CITY OF ALBUQUERQUE

October 10, 2007

Re: North 2nd St. Business Center Grading and Drainage Plan
Engineer's Stamp dated 10-4-07 (F15/D052)

Figure 1 - Private Access Road Capacity

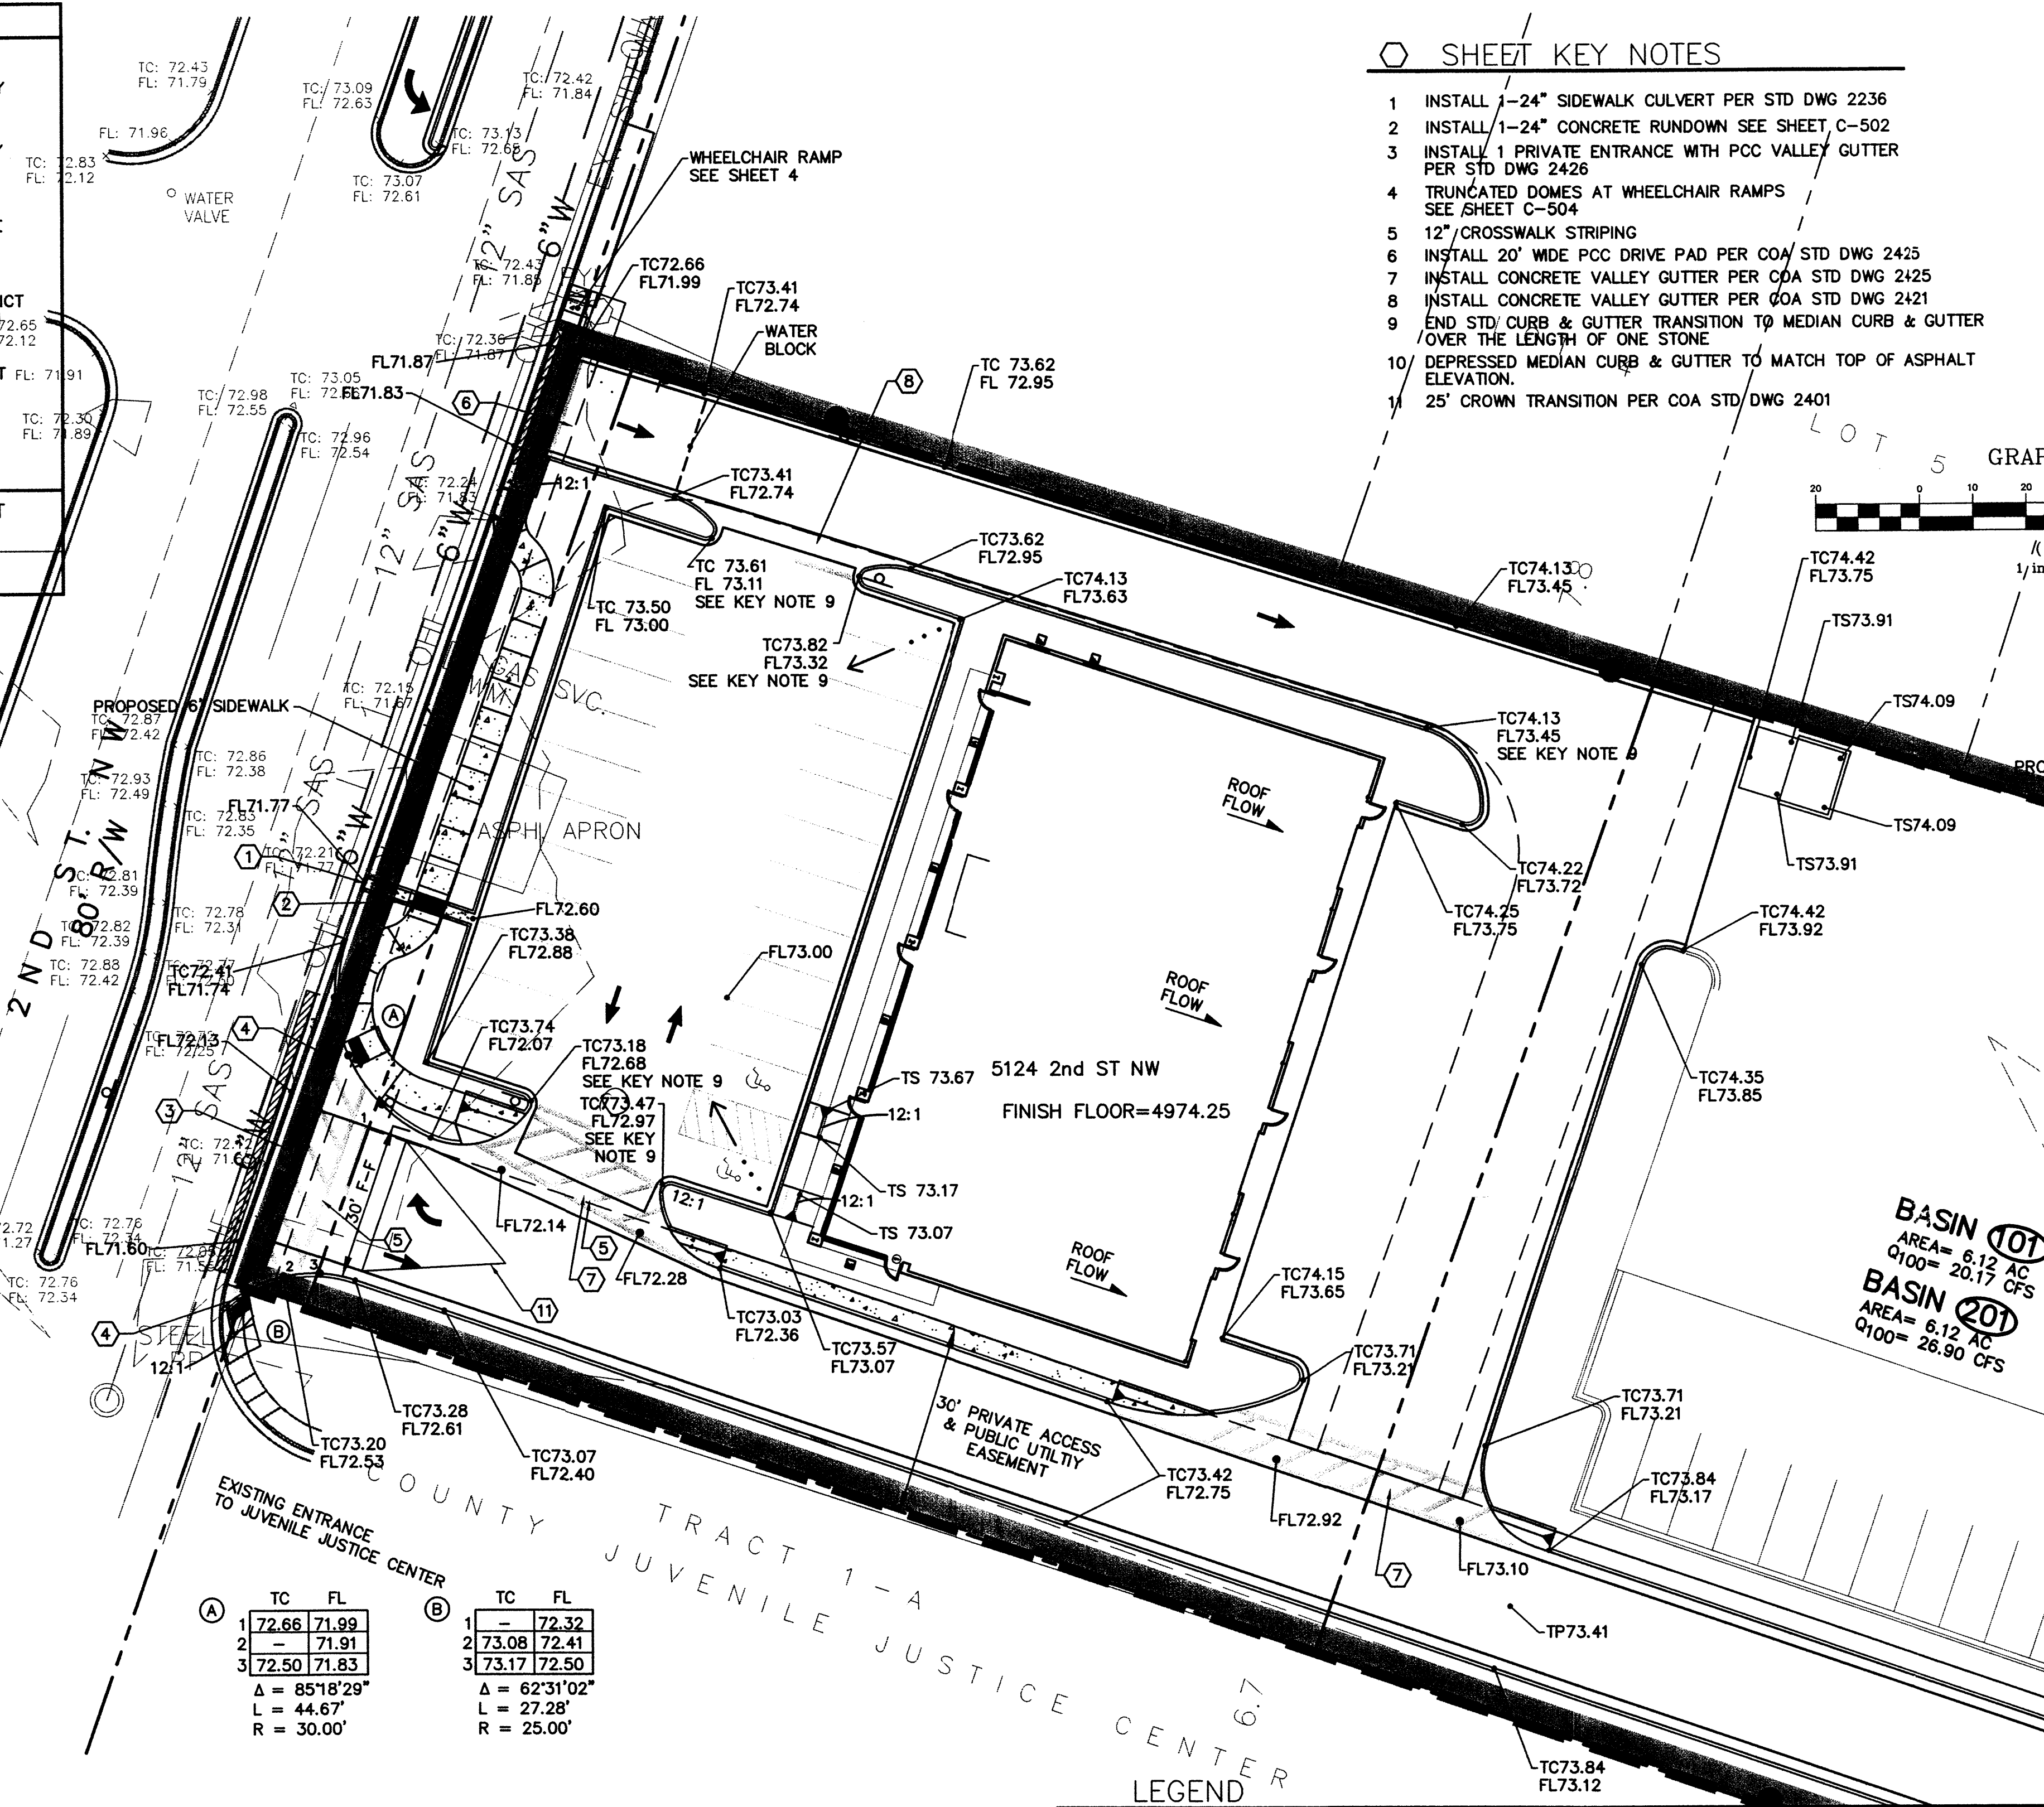
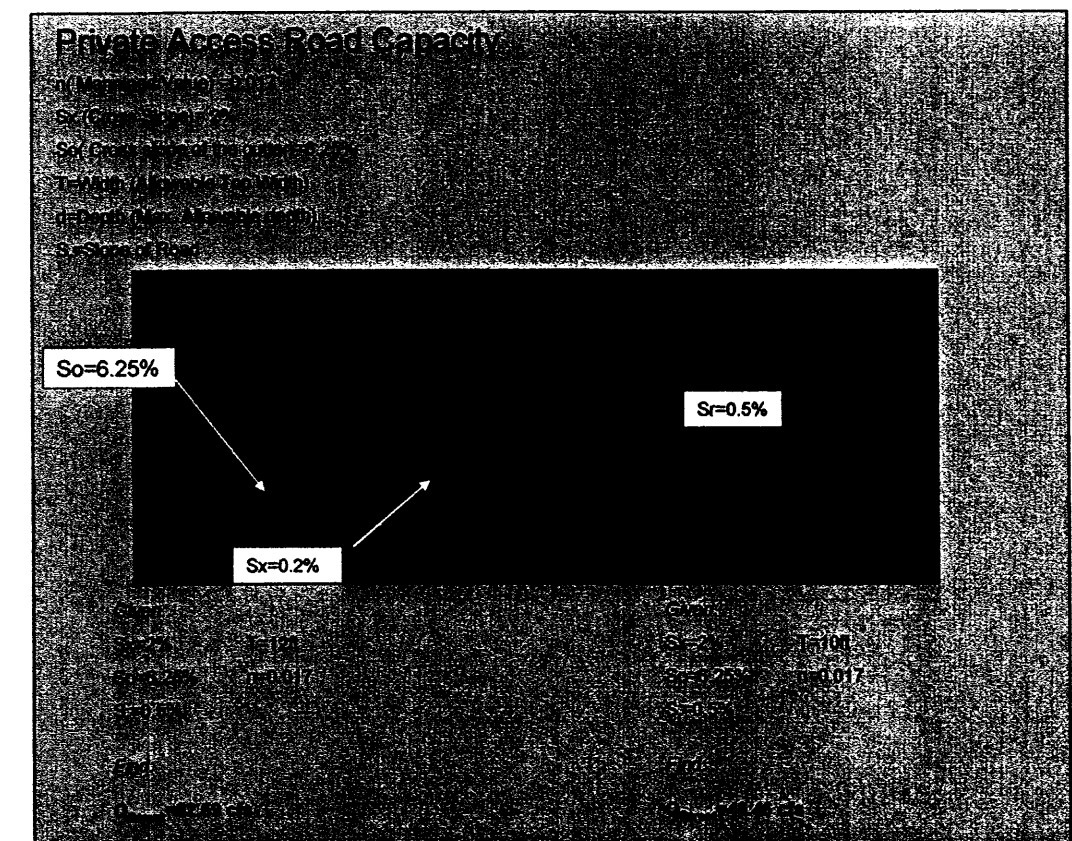
- As mentioned at DRC on Monday, October 8th, the grade of the private road needs to be increased to 0.5%. This will affect grades shown on this plan.

- The capacity of the private road was calculated using an incorrect longitudinal slope of 6.25%.
